From: Michael Eastham
Sent: 11 April 2019 14:44
To: Laura Gibbons; Mark Warwick
Cc: Planning.Responses; Nicola Spencer
Subject: FW: Updated Plans Walberton REVISED EMAIL 1
Attachments: LIND171208 SL.01 E.pdf; 3823_111_F_Landscape Masterplan.pdf

Please find attached the amended landscaping plans for WA/95/18/RES.

Site Layout

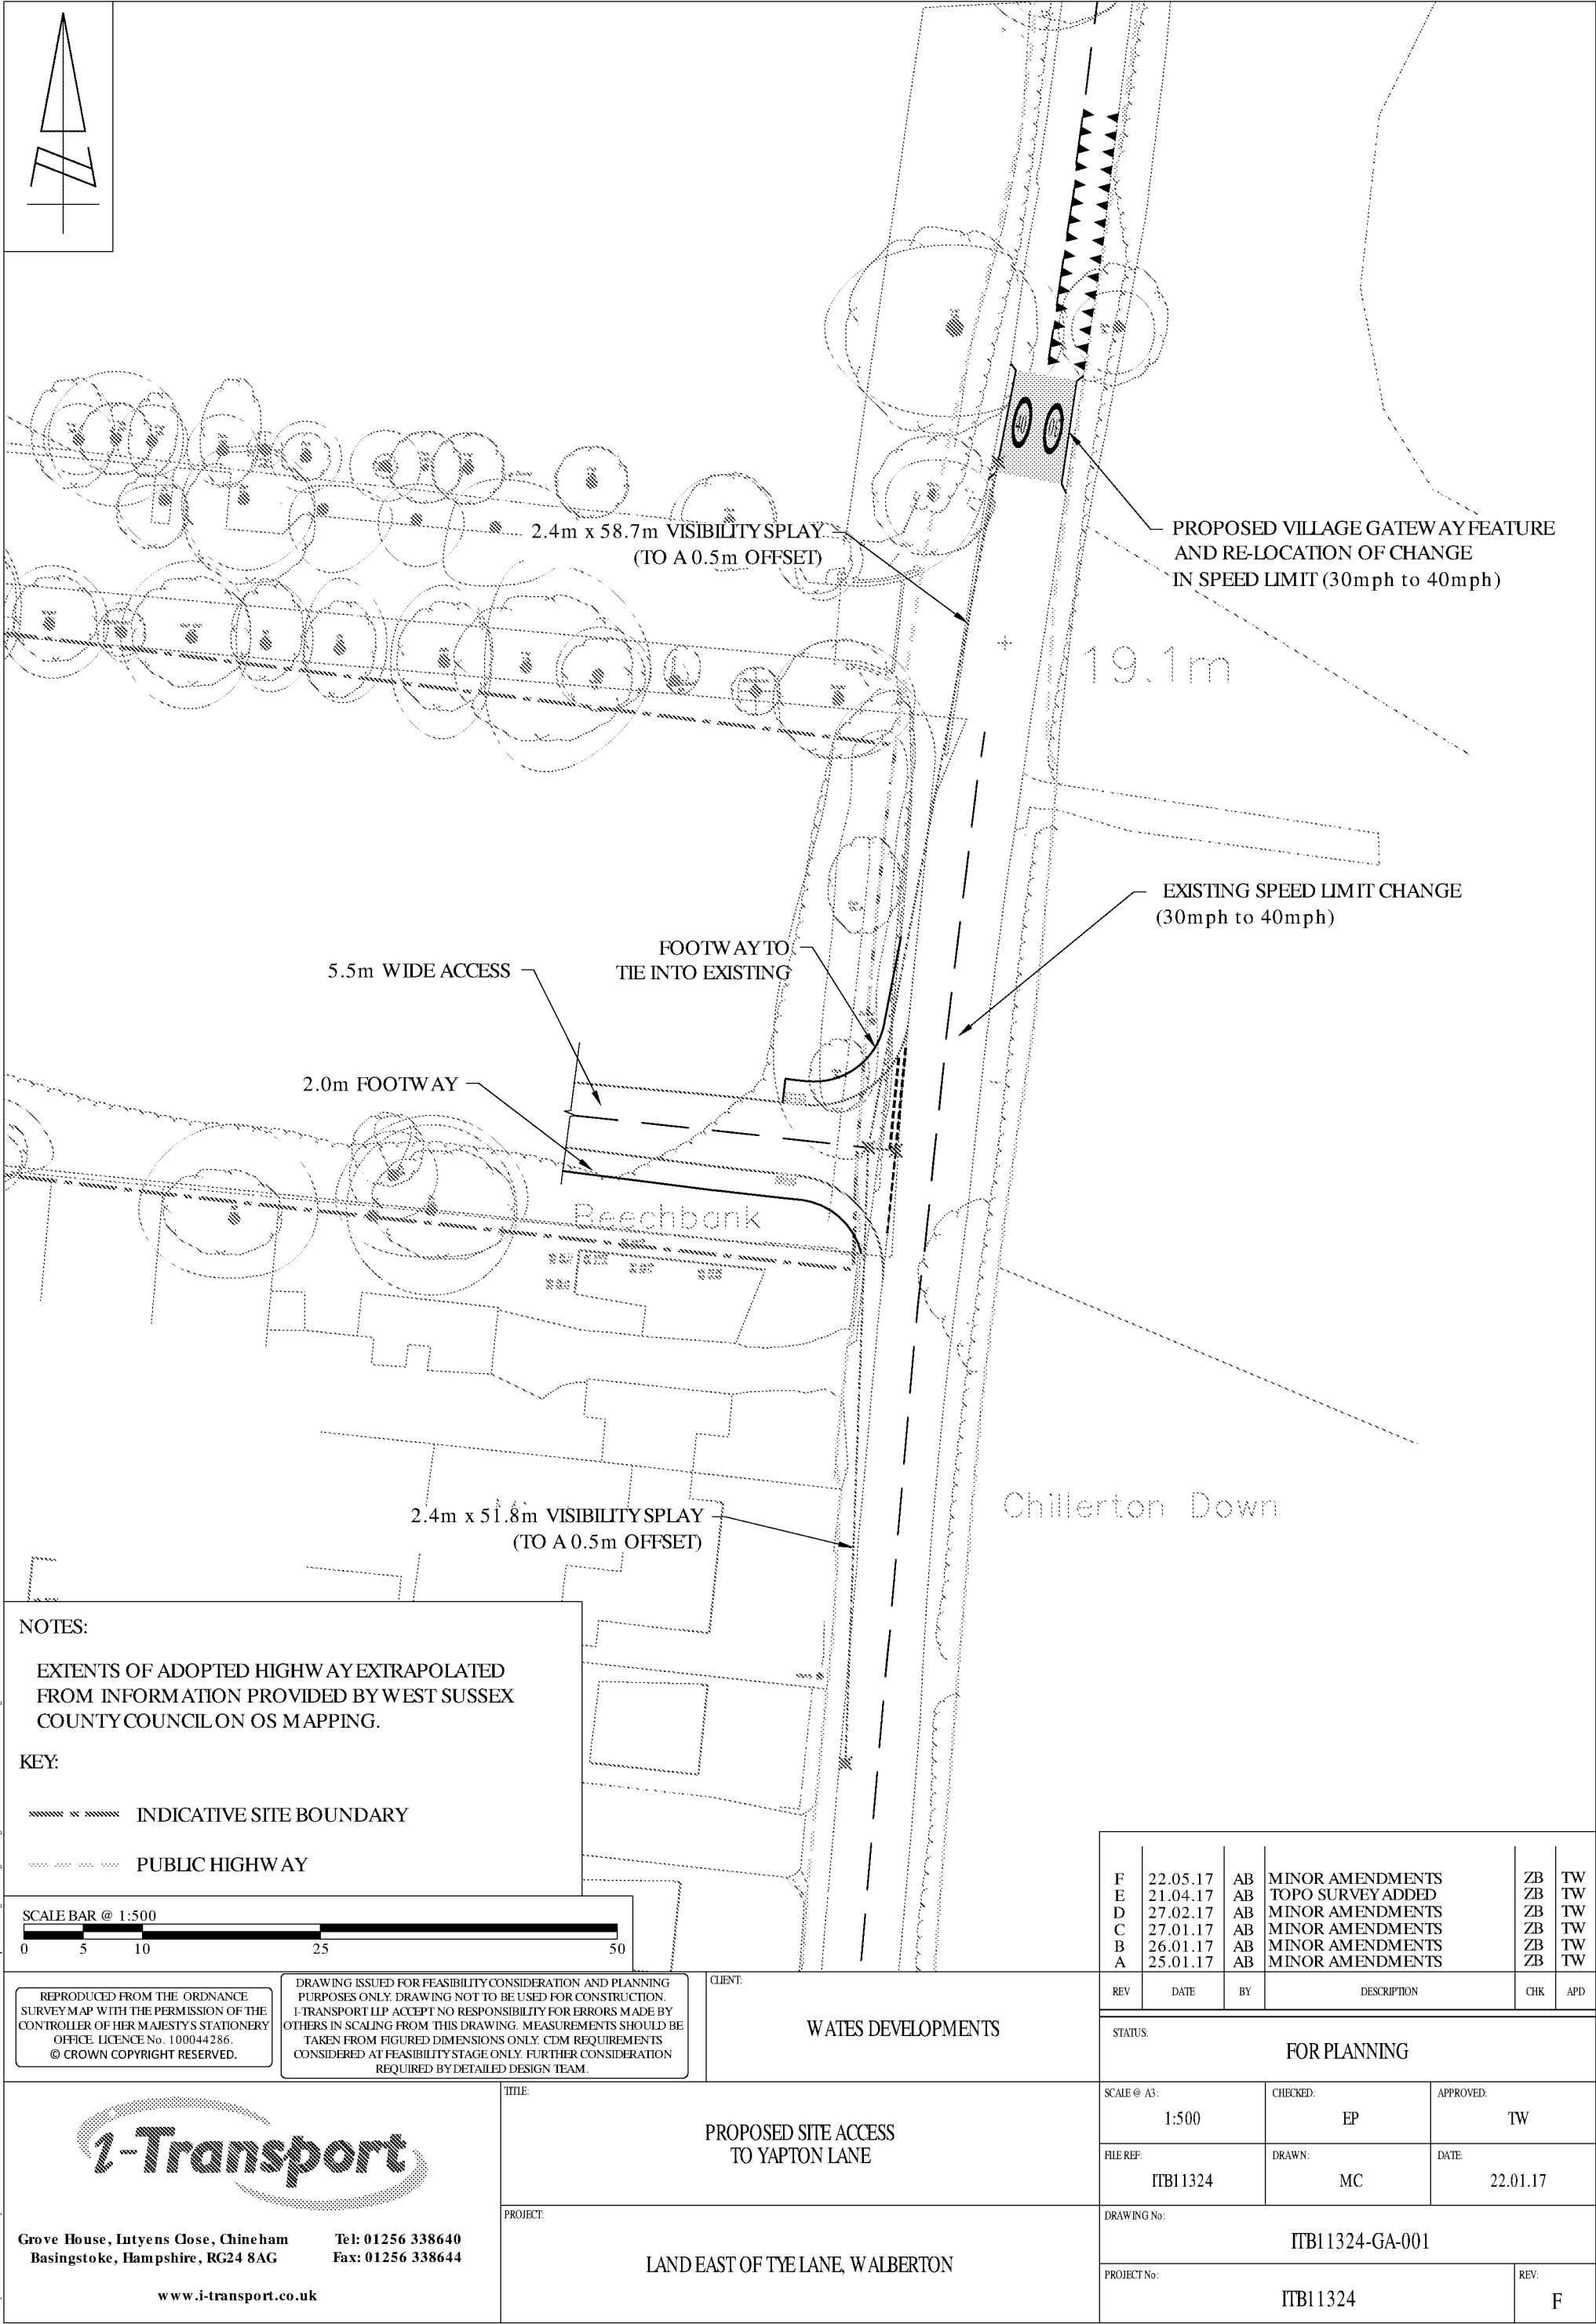
Are you satisfied with the proposed location of the emergency access?

Please find attached the revised plans which has shifted the path connection with Tye Lane slightly northwards to address Laura G comments.
